Your Ref: OWPC20984
Our Ref: A/158/18/PL 23-11-2018
Please ask for:
Mrs A Gardner

Variation of condition 1 imposed under A/8/18/PL relating to the substitution of approved plan drawings NO ADC 962 04 rev A & 13 rev B for drawings No ADC 962 20 & 21 (ground & first floor plans & roof plan). This application affects the character & appearance of the Angmering Conservation Area.

Land Rear Of 1 To 6 The Cottrells Angmering

Ground Floor Plan @ 1:100

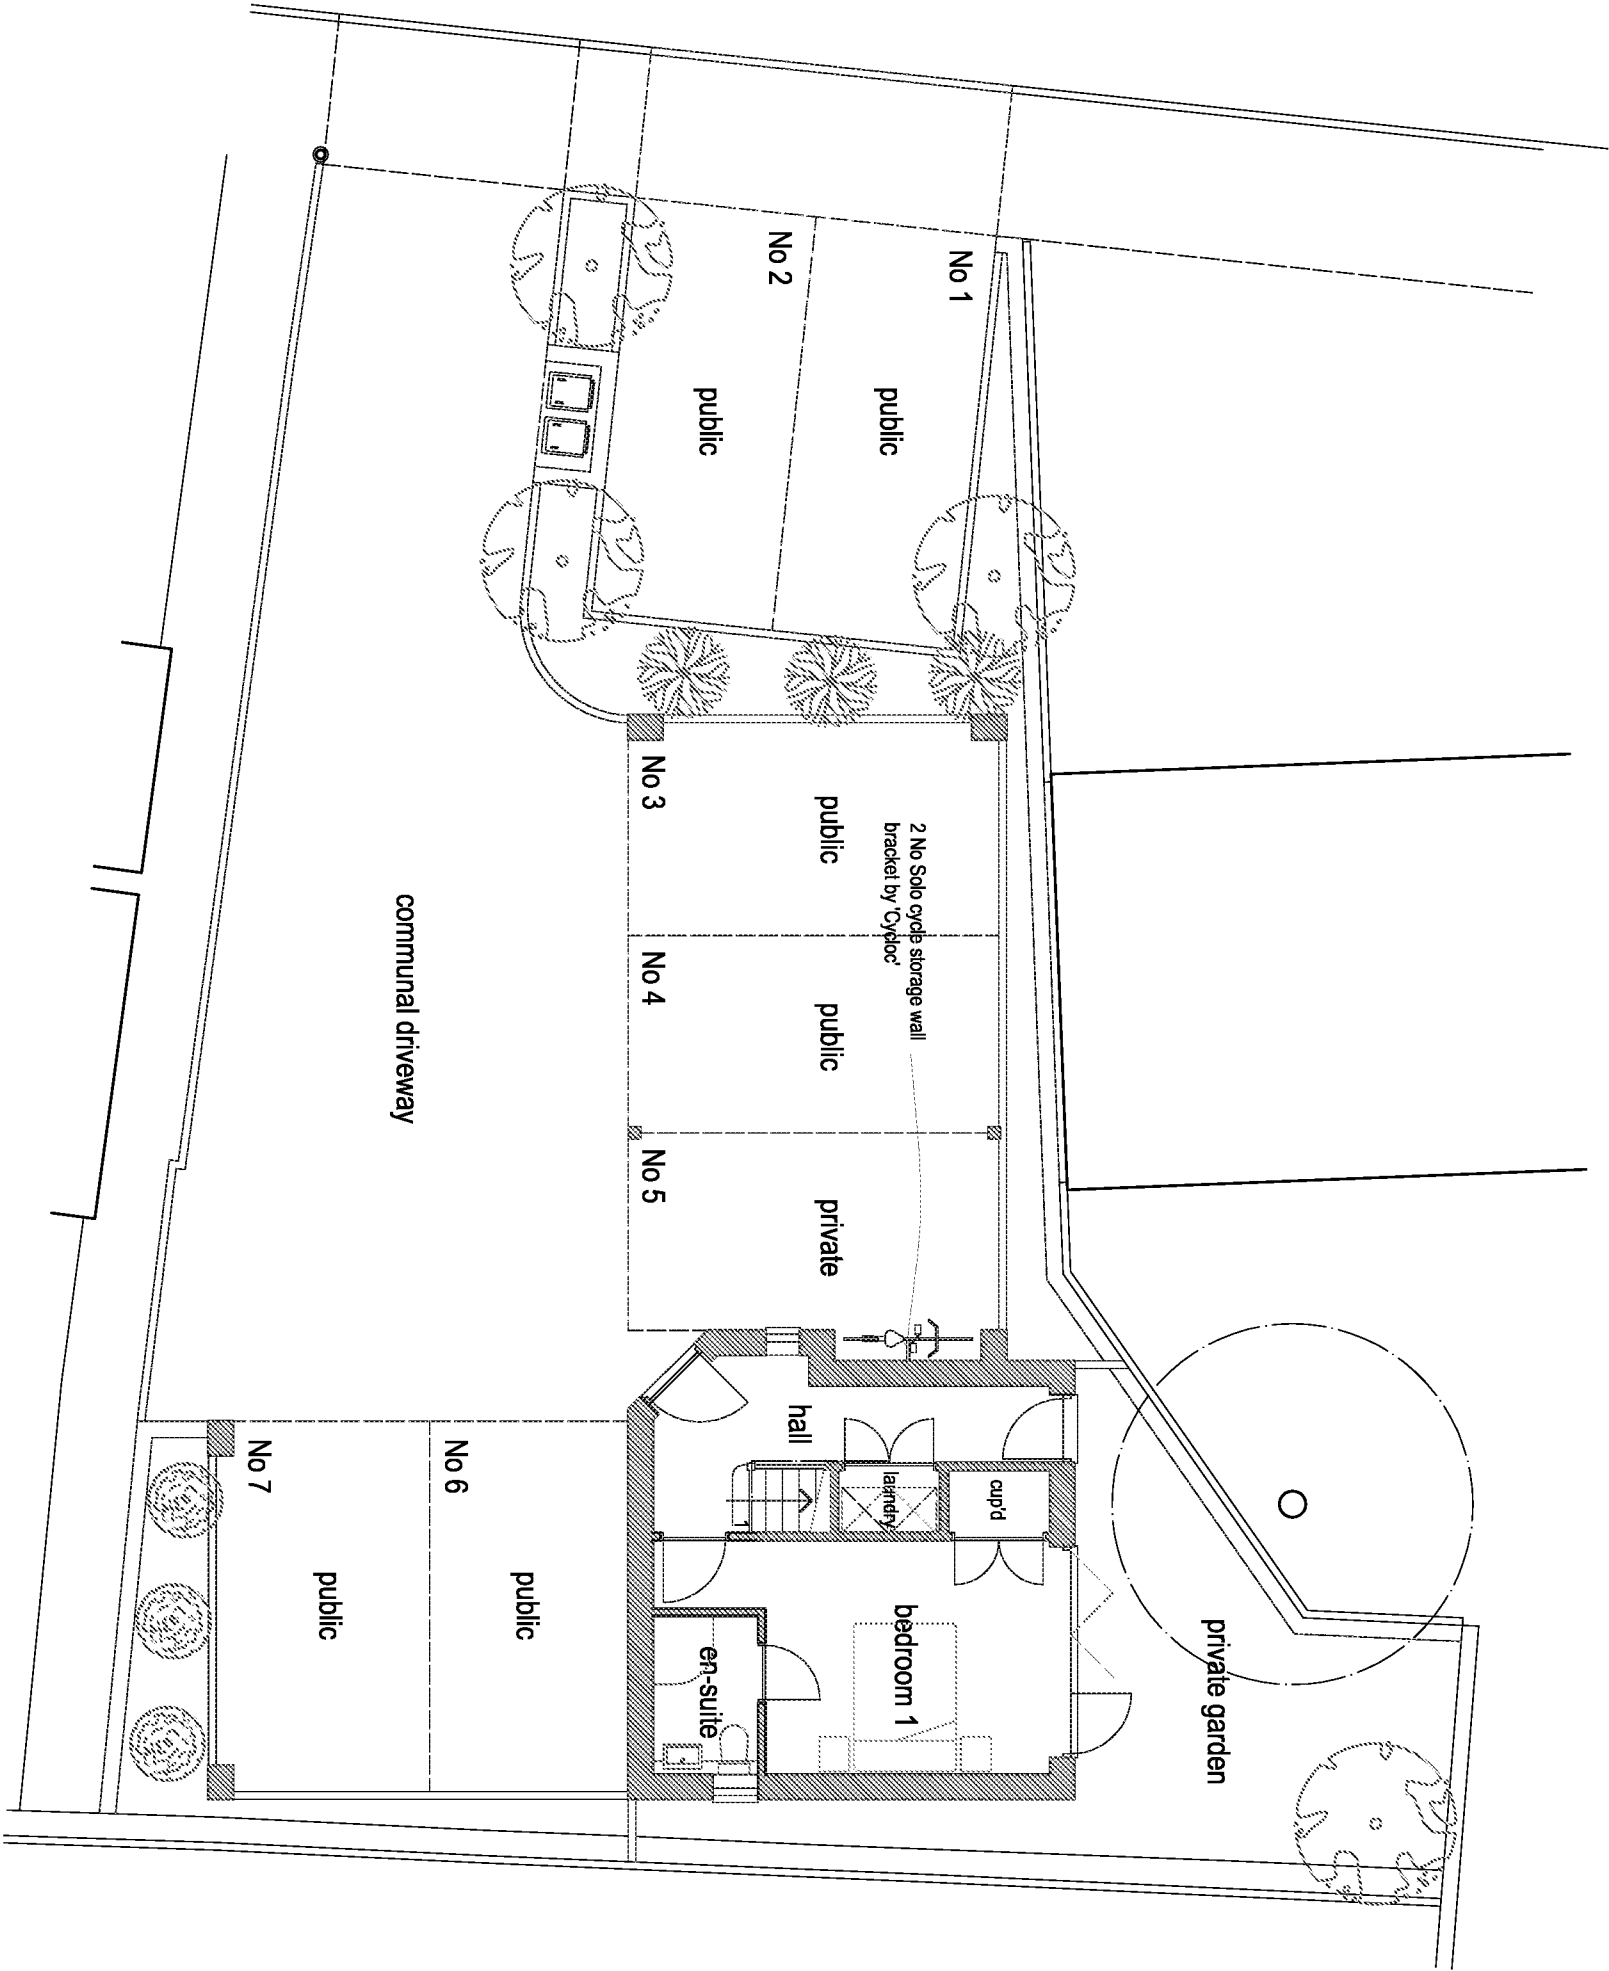
1. The original and subsequent planning applications for this dwelling all called this a two bedroom property, with the downstairs varying between storage and kitchen use. It is now obviously a third ensuite bedroom, and the attempts by the developers to rename one of the upstairs bedrooms "a study" is a blatant attempt at conforming to the two bedroom original application. Surely any room is classed as a "bedroom" if it can fit a bed? The number of bedrooms isn't decided by whatever nomenclature the developer decides to use.

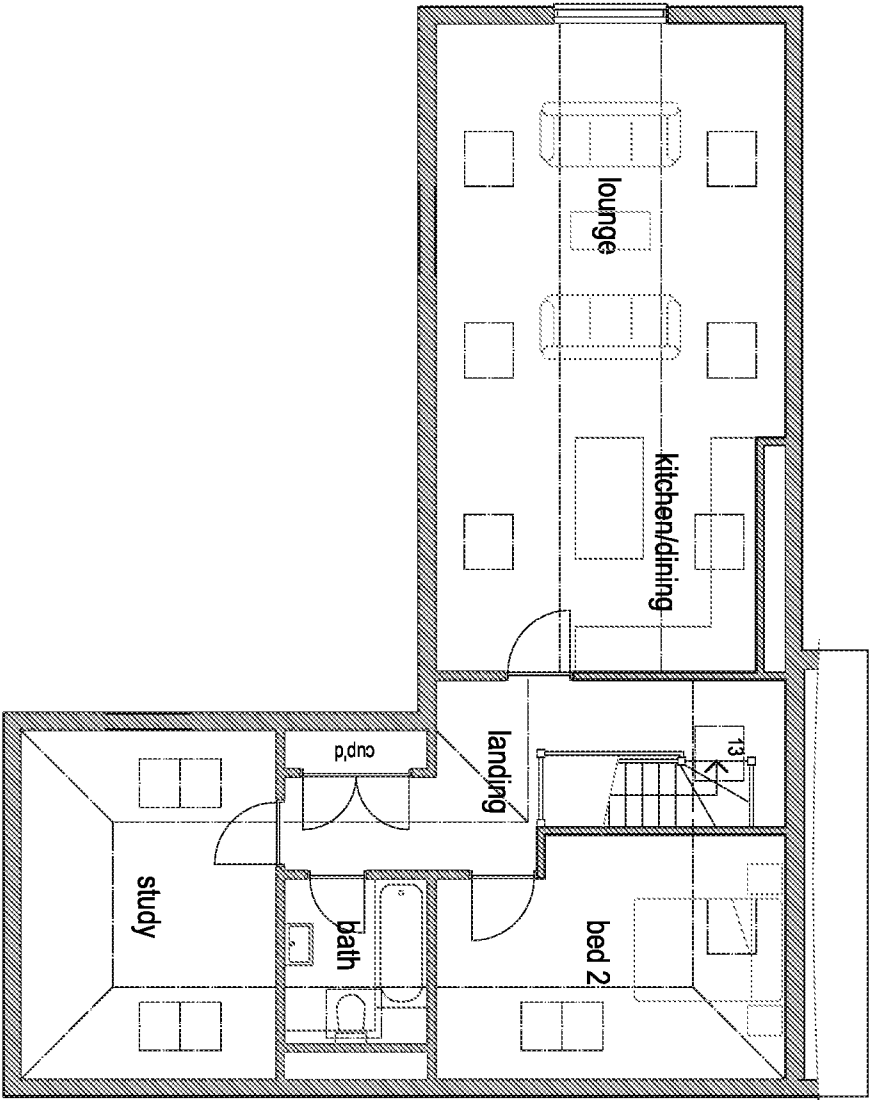
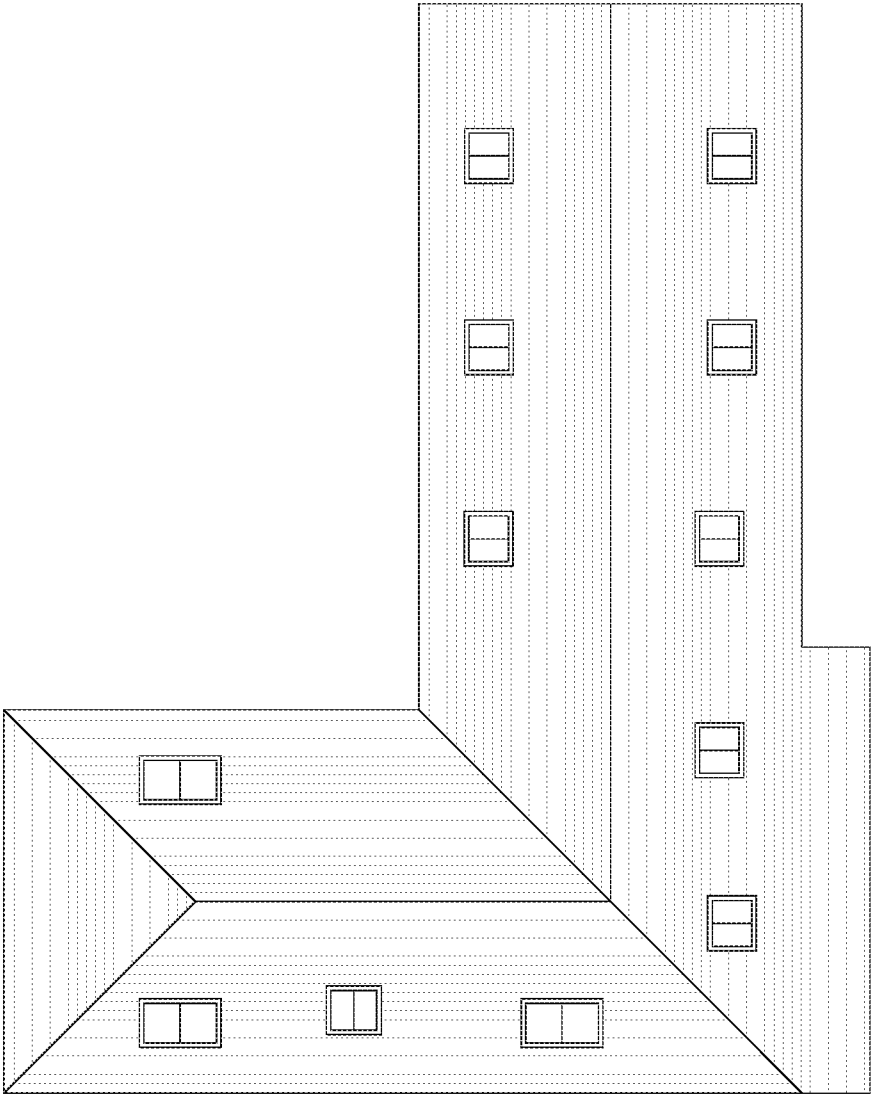
2. The upstairs windows remain exactly as built, which is contrary to the plans, and as such affords an unimpeded view of the rear of numbers 1-6.
